**KIRKLEES METROPOLITAN COUNCIL
INVESTMENT & REGENERATION SERVICE**

Reference No:	2026/70/90501/W
Site Address:	Site of Former Perseverance House, St Andrew's Road, Huddersfield, HD1 6RZ
Description:	Variation of condition 2 (plans) on previous permission 2024/91336 for erection of two storey office/workshop with detached store and associated works
Recommending Officer:	William Simcock

Application: 2026/90501

Proposal: Variation of condition 2 (plans) on previous permission 2024/91336 for erection of two storey office/workshop with detached store and associated works

drawing DETAILED ELEVATIONS

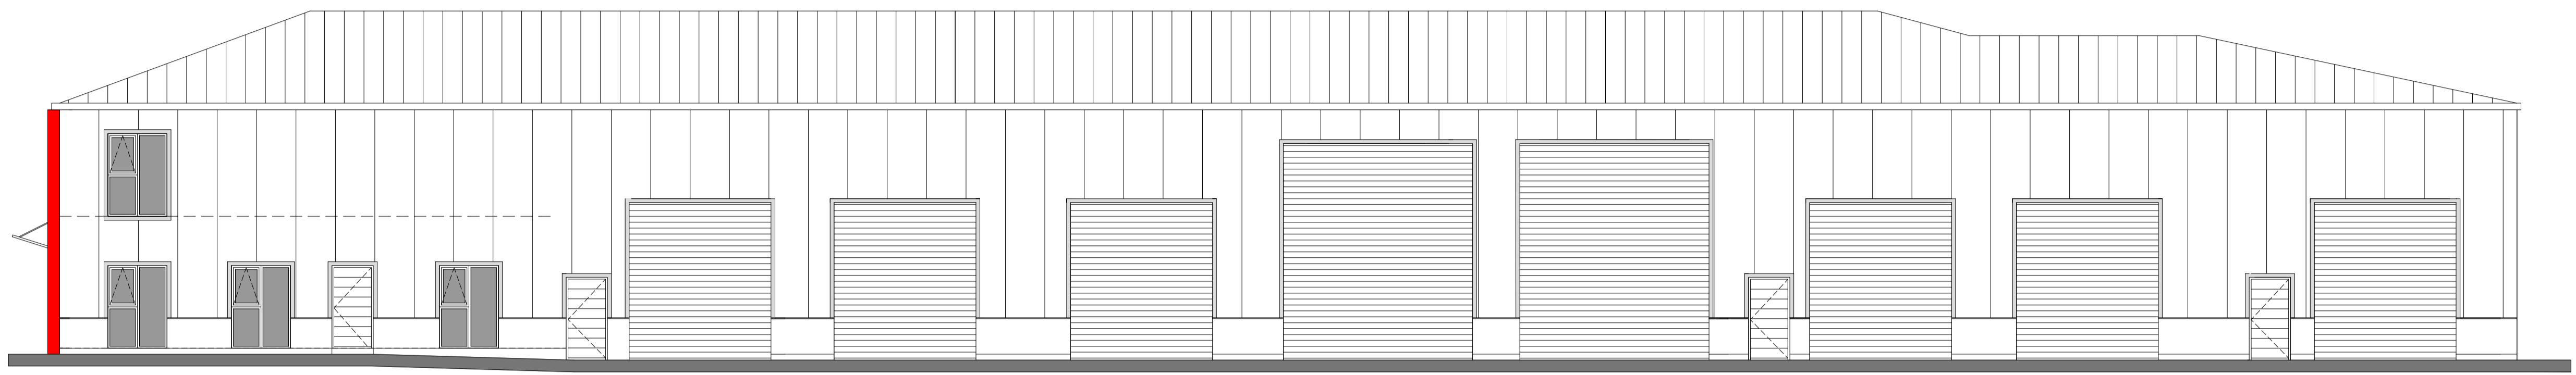
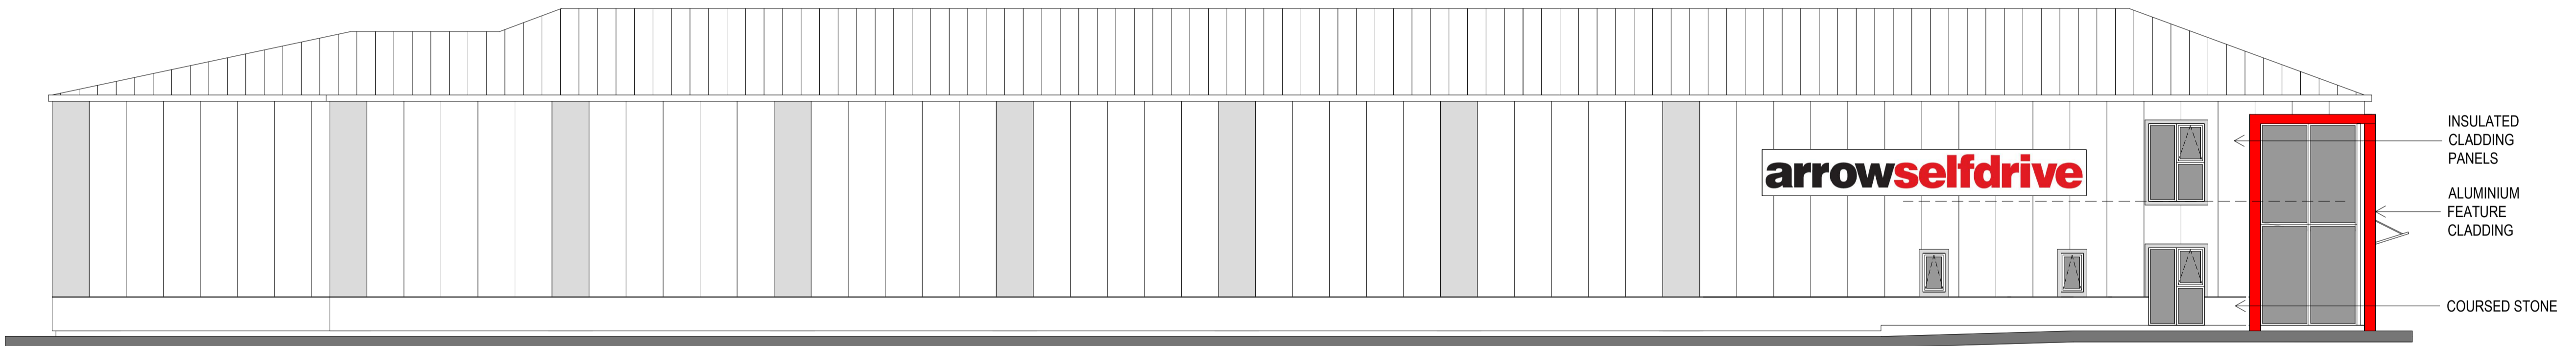
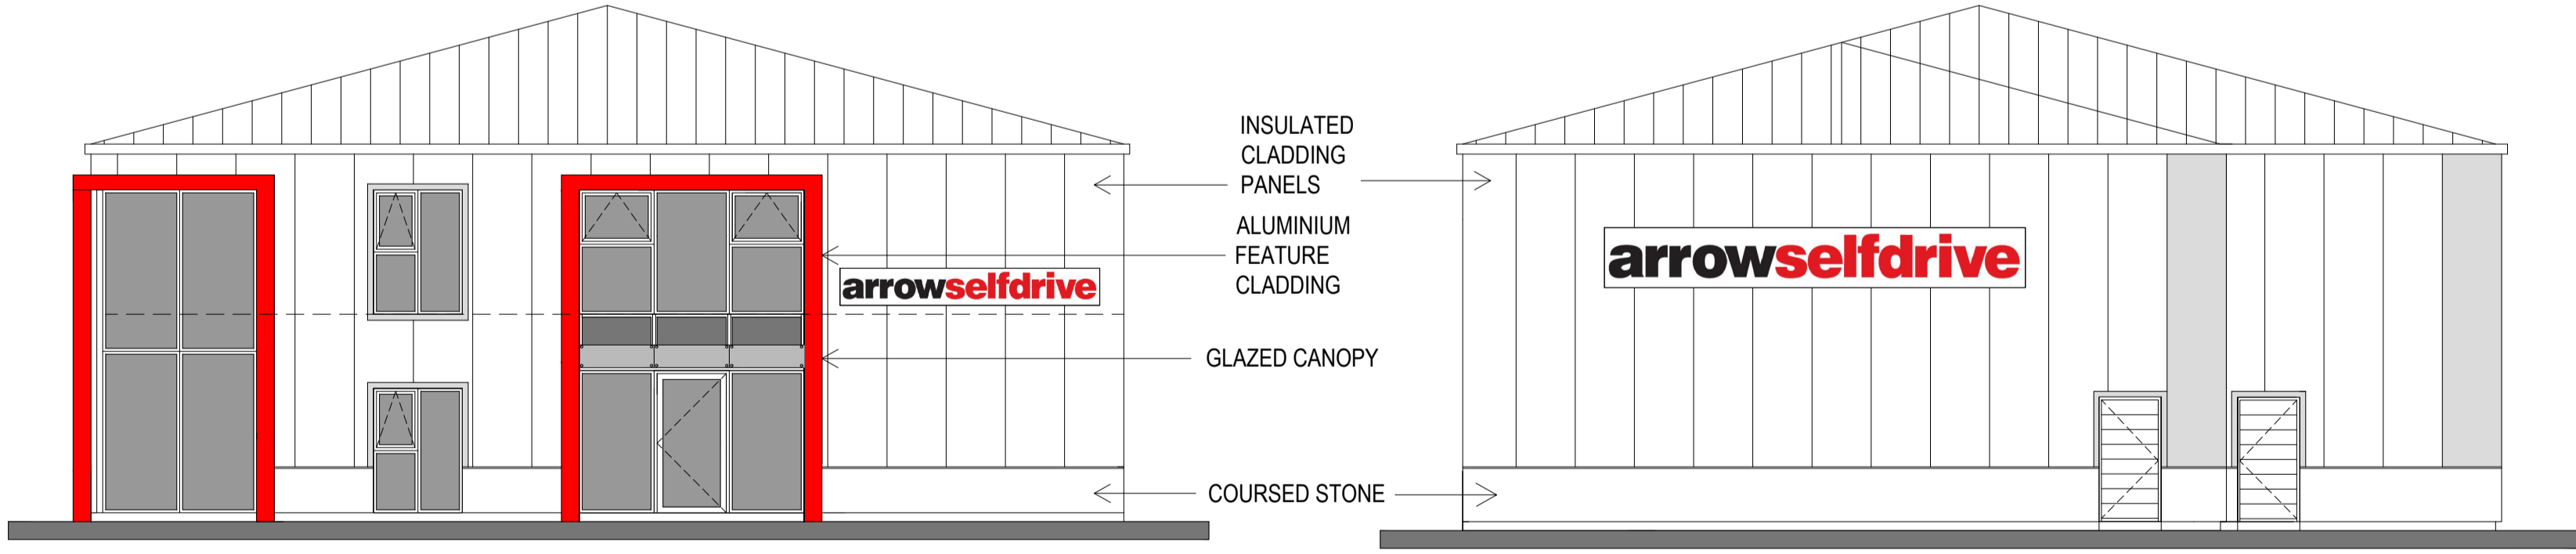
- The proposed eaves height has been increased from 6.30m to 6.525m, and the ridge height from 8.72m to 8.86m. This increase results from the steel frame specification being deeper than originally anticipated, leading to increased intermediate floor depths.

- The previously approved 900mm roof overhang has been omitted.

- The approved hip roof pitch of 15 degrees on all planes has been revised. Due to the updated steel frame design, roof pitches now vary between 12 degrees and 20 degrees.

- The widths of the roller shutter doors have been amended (reduced in width) to better accommodate the operational vehicle sizes

- A new glazed canopy has been introduced above the main entrance.

- Additional external door openings are proposed on the north (two) and east (three) elevations. These are required to ensure compliance with current fire safety and means of escape regulations.

It is considered that the increase in the eaves and ridge height of the building would not result in a structure that would seem disproportionately large within the site or in the context of its surroundings, since most surrounding buildings are taller, being two to three storeys in height. The changes to roof pitch and the deletion of the roof overhang are also not considered to be minor modifications that would not negatively affect the quality of the development.

The additional personnel doors and the small adjustments to the dimensions of the roller shutter doors are considered to have no significant impact upon the character or appearance of the proposed building.

The glazed entrance canopy, based on scaled measurements, extends 900m from the face of the building, not 1.2m as set out in the supporting statement. Its maximum height from ground is 3.5m. It is considered that this feature would appear very small and low-key in the context of the building and the site, therefore not materially impacting upon the visual quality of the building.

In conclusion, it is considered that the development as modified would not result in an inferior quality of development compared to the scheme as originally approved and would fulfil the aims of Policy LP24(a) and the relevant parts of Chapter 12 of the NPPF.

client	ARROW SELF DRIVE		
project	NEW PREMISES ST ANDREWS ROAD HUDDERSFIELD HD1 6RZ		
drawing	PROPOSED PLANS		
revision	notes	date	drawn
A	DESIGN REVISION	01.26	MG
scale :	1:100 AT A1	04.24	PB
project no.	drawing no.	revision	
2322	02	A

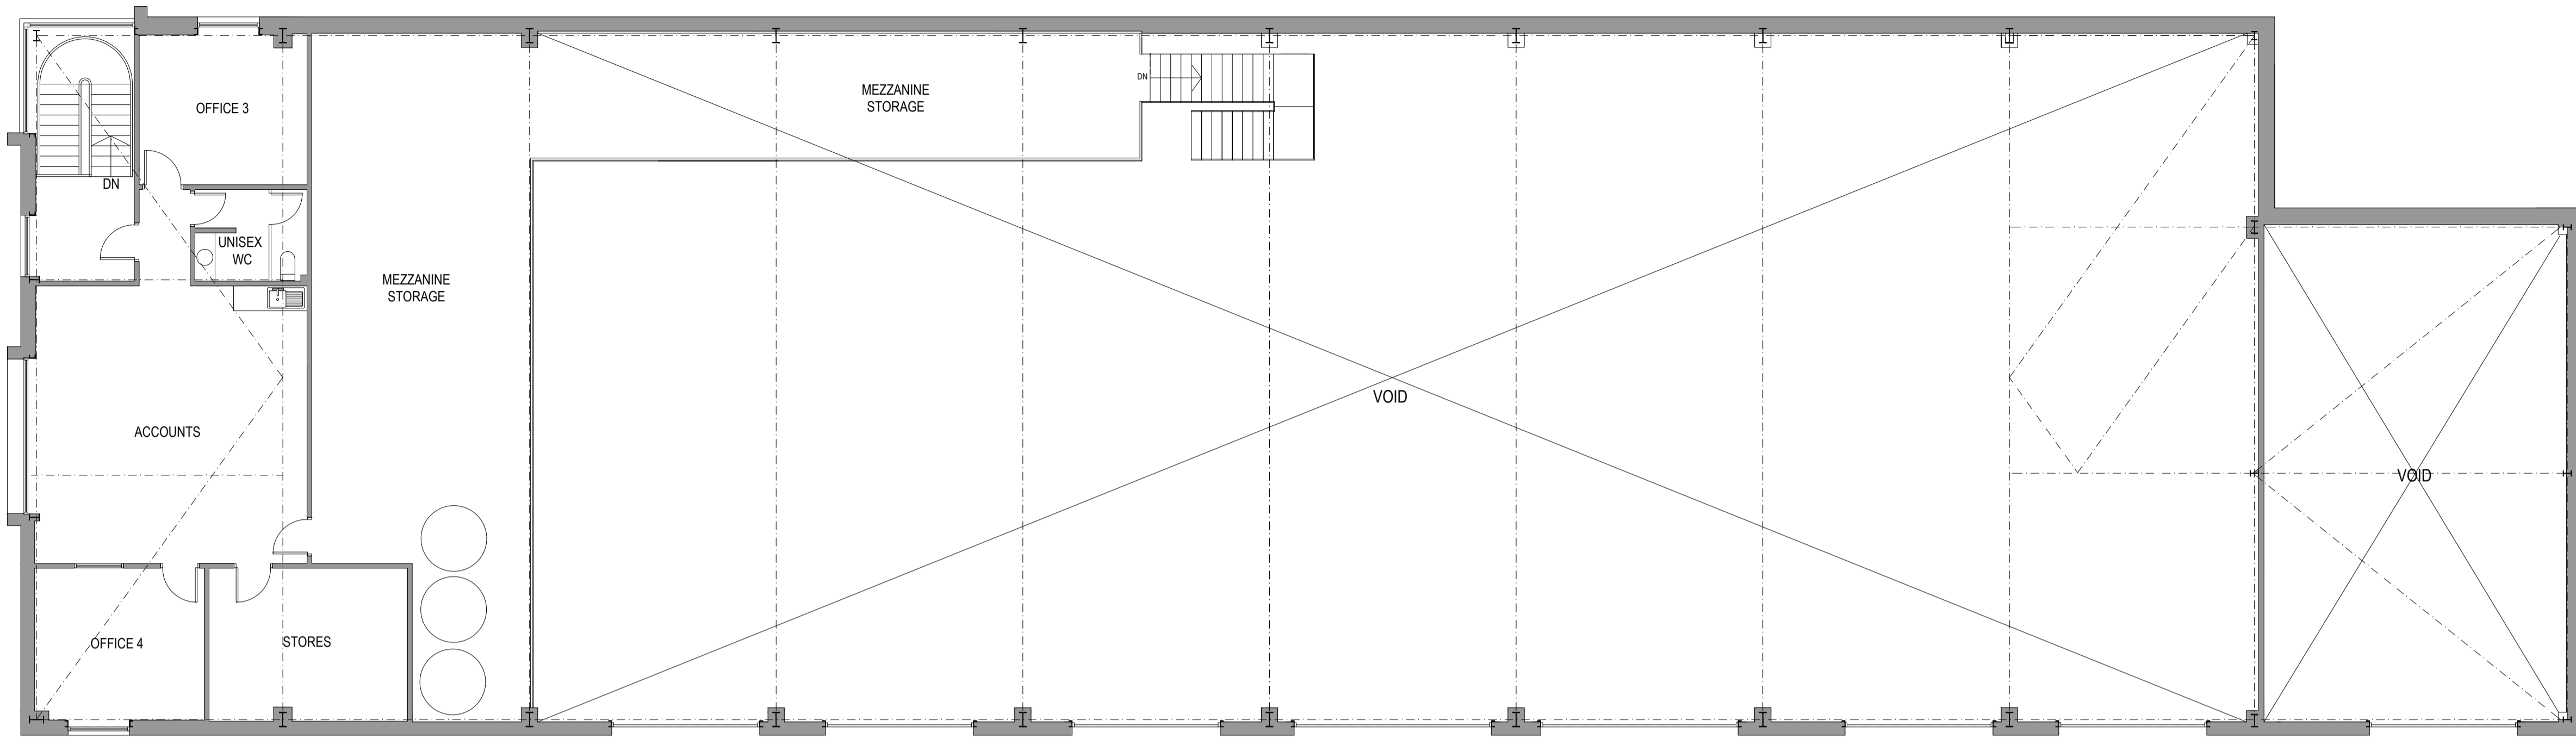
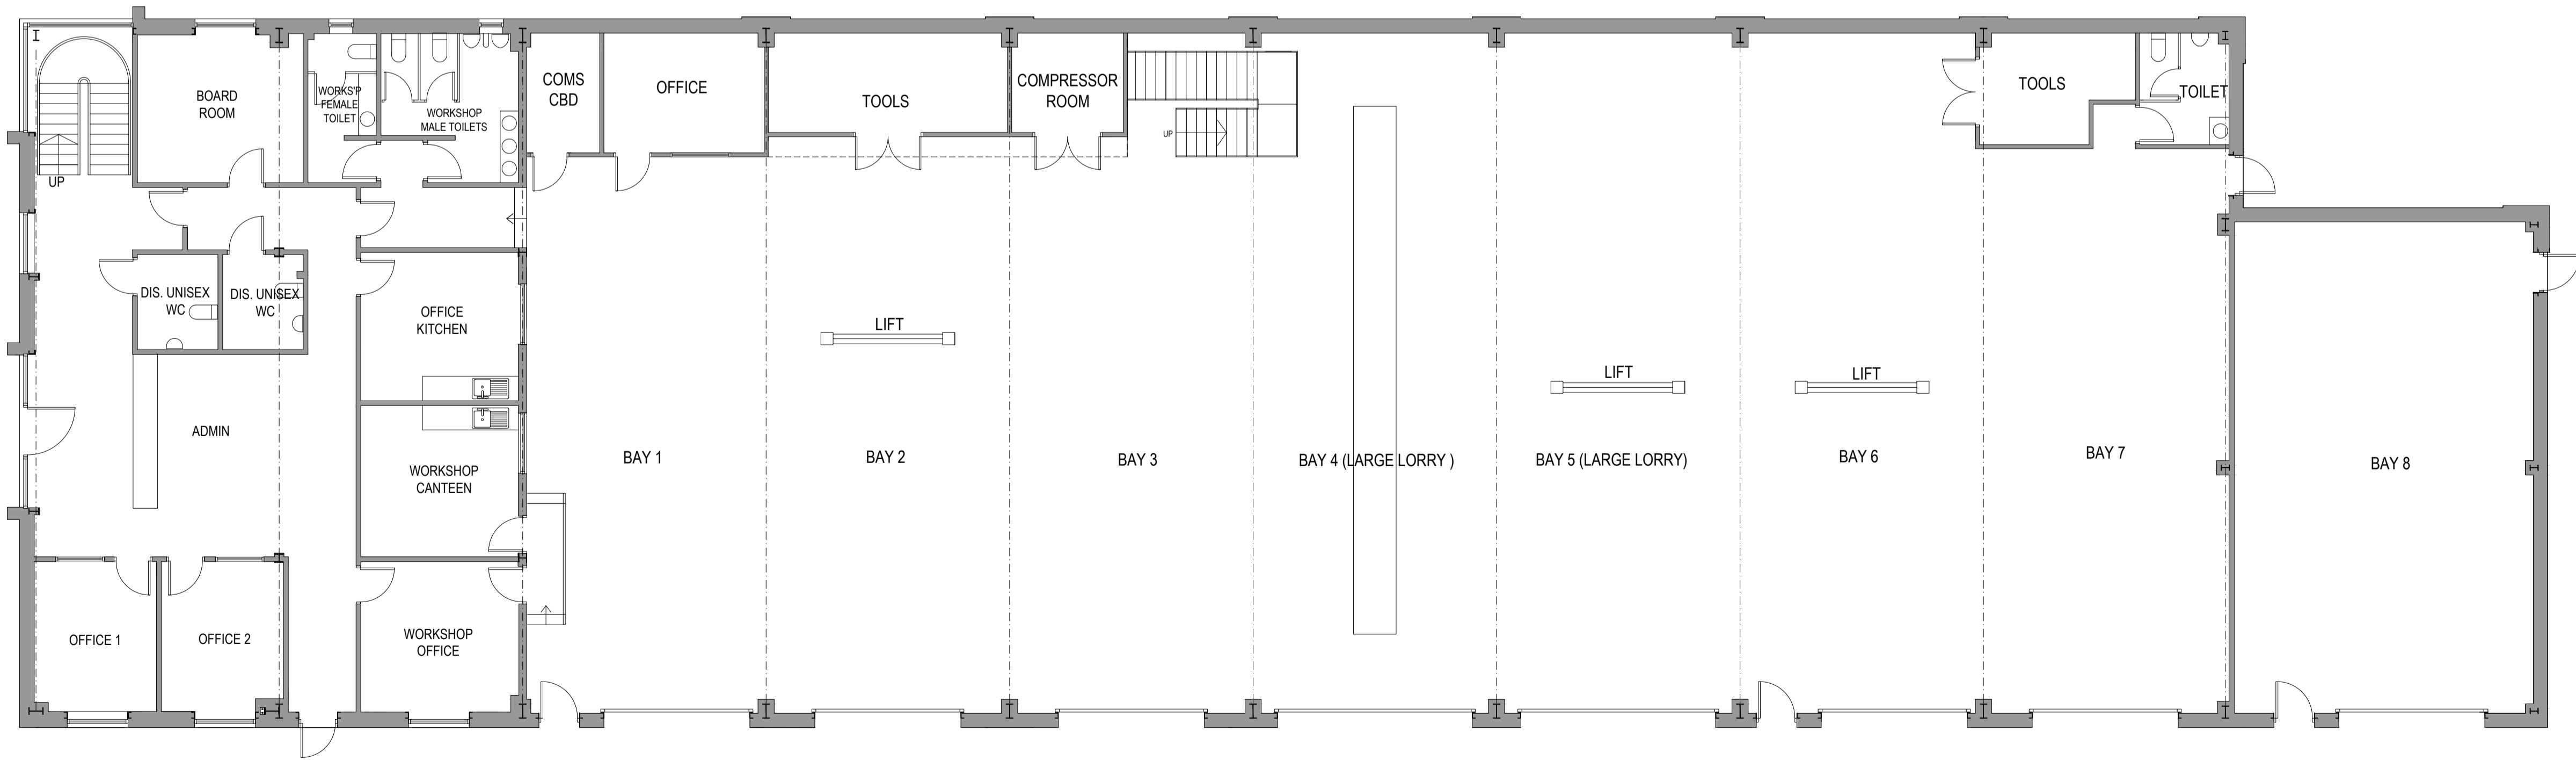
- A minor internal layout change is proposed whereby the ground floor office and office kitchen locations have been swapped for improved functionality.

- A 300mm level difference between the office floor and workshop floor is proposed to respond to on-site ground levels and improve construction practicality.

The adjustments to internal layout and floor level are considered to be non-material since they would not directly affect the external appearance of the building.
